CITY OF ALBUQUERQUE

March 23, 2016

Re: Christmans Apartments
2040 Willis Pl., SW
Traffic Circulation Layout
Engineer's/Architect's Stamp 3-8-16 (J13-D202)

CHRISTMANS APARTMENTS
SITE PLAN
ALBUQUERQUE, NM
PROJECT #1548

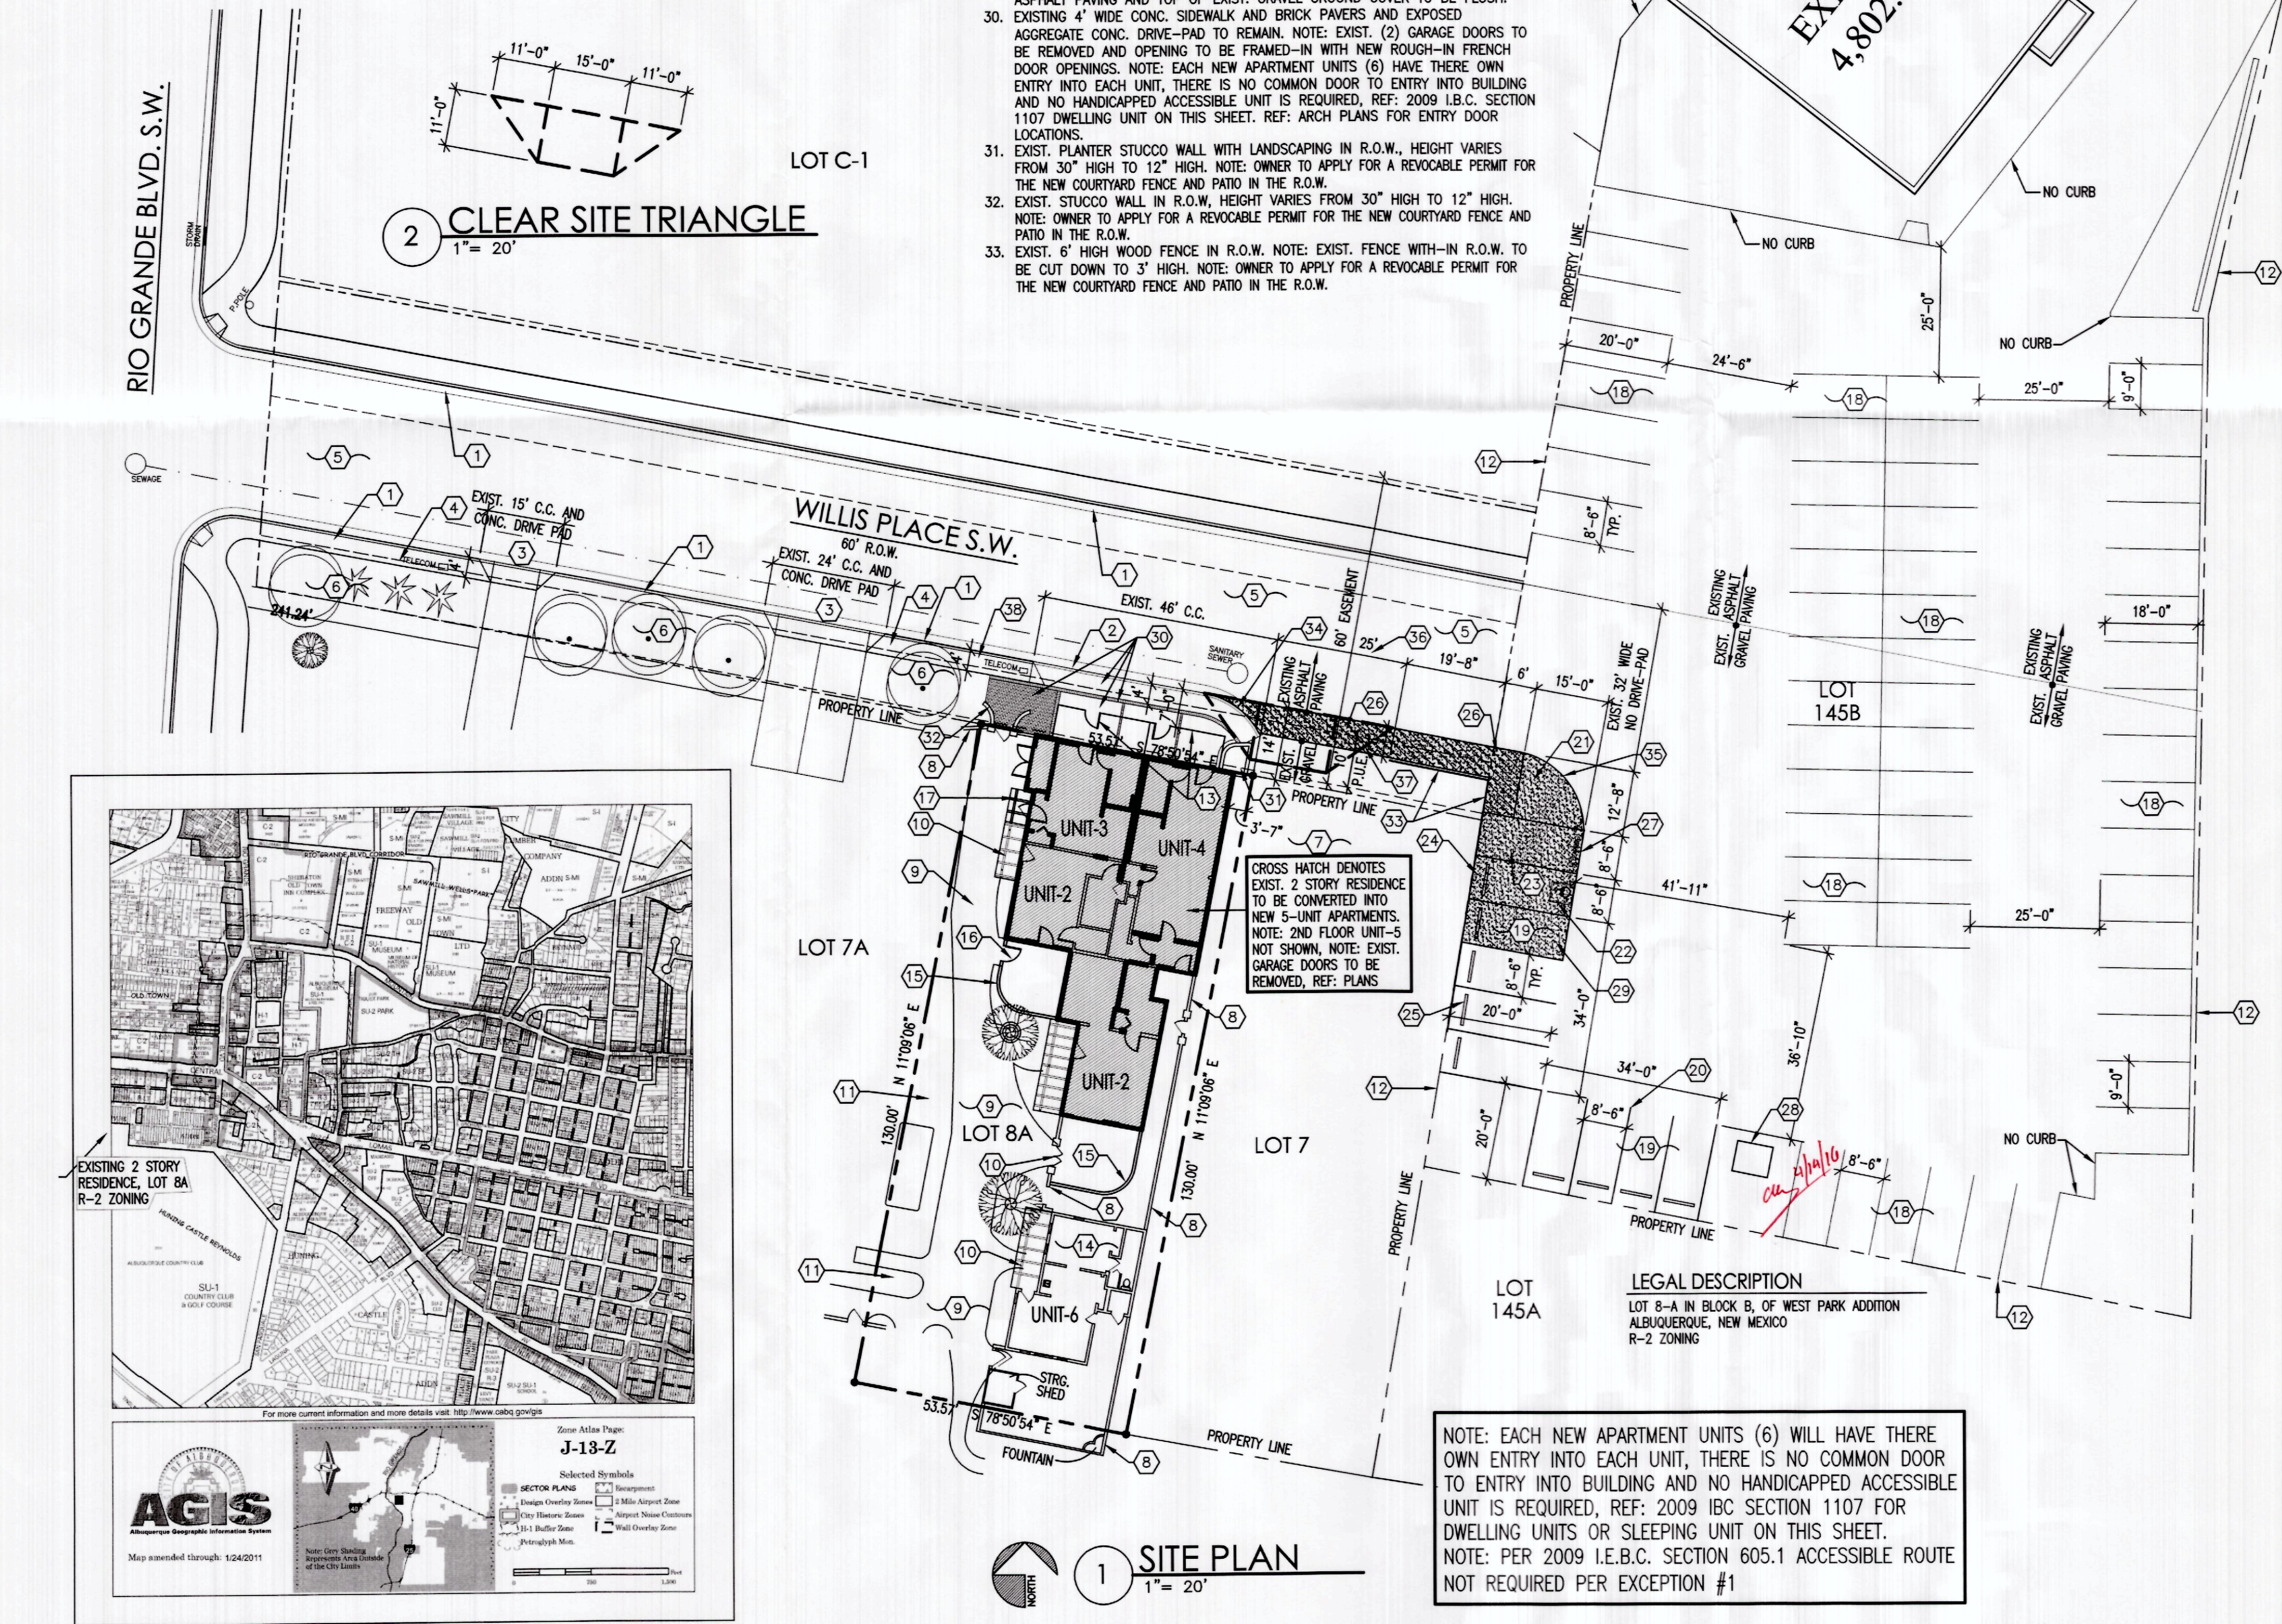
1. Please detail and dimension all existing sidewalks, curb cuts and drive pads.
2. Grades and slopes on the handicap accessible pathway appear to be too large. Please provide more detail.

3. Please list the width and length for all existing and proposed parking spaces. In review of the submitted drawing, there seems to be a mistyped parking length for the parking spaces to the east of the project site.

4. Show all drive aisle widths and radii.
5. Per DPM, a 6 ft. wide ADA accessible pedestrian pathway is required from the public sidewalk to the building entrances. Please clearly show this pathway and provide details of sidewalk dimension and slope.

6. Per DPM, a 6 ft. wide ADA accessible pedestrian pathway is required from the HC parking stall access aisles to the building entrances. Please clearly show this pathway and provide details. The ADA pathway must be a solid surface and have appropriate striping. Roll curb is not permissible for ADA pathway.

7. A Revocable Permit will be required for the fencing and any patio in the ROW.
8. Please state if the garage entrances are still in place and being used or if they have been renovated and removed from the apartment structure.

9. Service vehicle and/or refuse vehicle maneuvering must be contained on-site; provide a copy of refuse approval.
10. Please provide a sight distance exhibit (see the *Development Process Manual, Chapter 23, Section 3, Mini Clear Sight Triangle*). Please provide this detail for entrance/exit on Willis Place.

11. Please add the following note to the clear sight triangle: "Landscaping and signage will not interfere with clear sight requirements. Therefore, signs, walls, trees, and shrubbery between 3 and 8 feet tall (as measured from the gutter pan) will not be acceptable in this area."
12. Unused curb cuts must be replaced with sidewalk and curb & gutter. A build note must be provided referring to the appropriate City Standard drawing.
13. All broken or cracked sidewalk must be replaced with sidewalk and curb & gutter. A build note must be provided referring to the appropriate City Standard drawing.
14. Please include a copy of your shared access agreement with the adjacent property owner.
15. Please include two copies of the traffic circulation layout at the next submittal.
